Arun District Conservation Area Advisory Panel
c/o Civic Centre

14th June 2021

Application No: BE/69/21/PL
Site Address: Land adj to Walnut Tree Cottage Shripney Lane Bersted PO22 9NR
Description of works: Erection of detached single storey, two bedroom dwelling and reinstatement of double garage to Walnut Tree Cottage from annexe/holiday let (Resubmission of BE/79/19/PL). This application may affect the character and appearance of the Shripney Conservation area. This application is within CIL Zone 3 and is CIL liable as new dwelling.

Figure 4: Alterations to annexe/holiday let

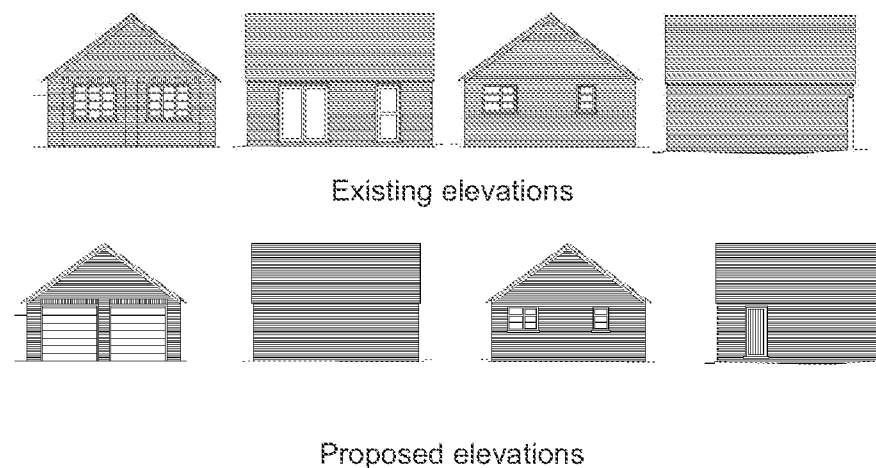
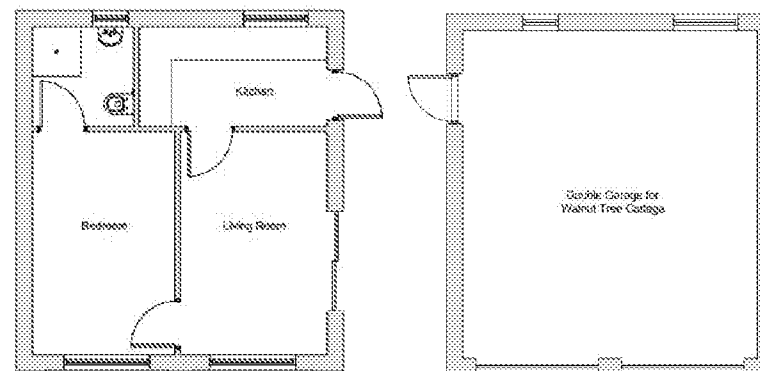
The appearance of the new garage doors to the former annexe could be improved if they were of painted timber vertical boarding rather than the horizontal panels shown on the drawings.
